From: Jamie Erken <jamie.erken@innerwest.nsw.gov.au>
Sent: Monday, 17 October 2016 4:09 PM
To: Sally Munk
Subject: FW: Request for Secretary's Environmental Assessment Requirements - Boral St Peters

Please see below some comments on section 6.5 (surface water) of the document for SEAR.

Section 6.5 – surface water

**Figure 2 – Site Operations**

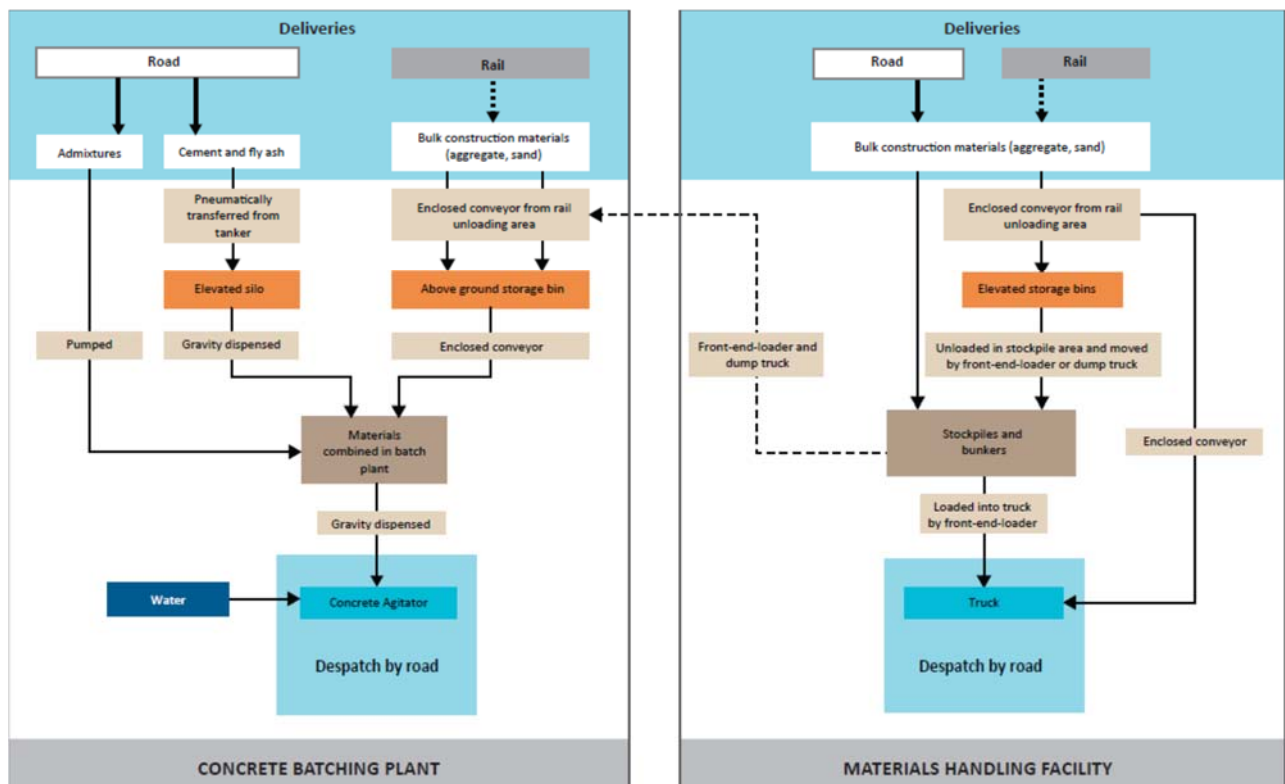
Figure 2.1 of the document shows the existing water management facility. This appears to be a first flush system. No details are available on storage and operational conditions of the facility. Assumed, it stores the runoff from the early stage of rainfall events and traps contamination from first flush. The rainfall volume in excess of the storage capacity appears to be bypassed and discharged to Alexandra Canal.

Could we have the details on the current arrangement of the storage facility including the site drainage network and operational protocols of the storage facility? How the stored water is used for dust suppression at site? Assumed, water from the storage is pumped into a dust suppression tanker and then used at site. Could we have the details on the amount of water from the storage facility and potable water used for dust suppression on a yearly basis? Does Boral have the records on the volume of runoff from the site discharges to Alexandra Canal on an annual basis?

There will be requirements for additional water for dust suppression in the upgraded conditions of the plant. This would require a larger storage facility for intercepting on-site stormwater runoff to minimise the usage of high-grade potable water for dust suppression. A detailed analysis and modelling would be required to determine the upgraded footprint of the runoff storage facility and its operational protocols including the by-pass stormwater volume to Alexandra Canal from the site on an annual basis.
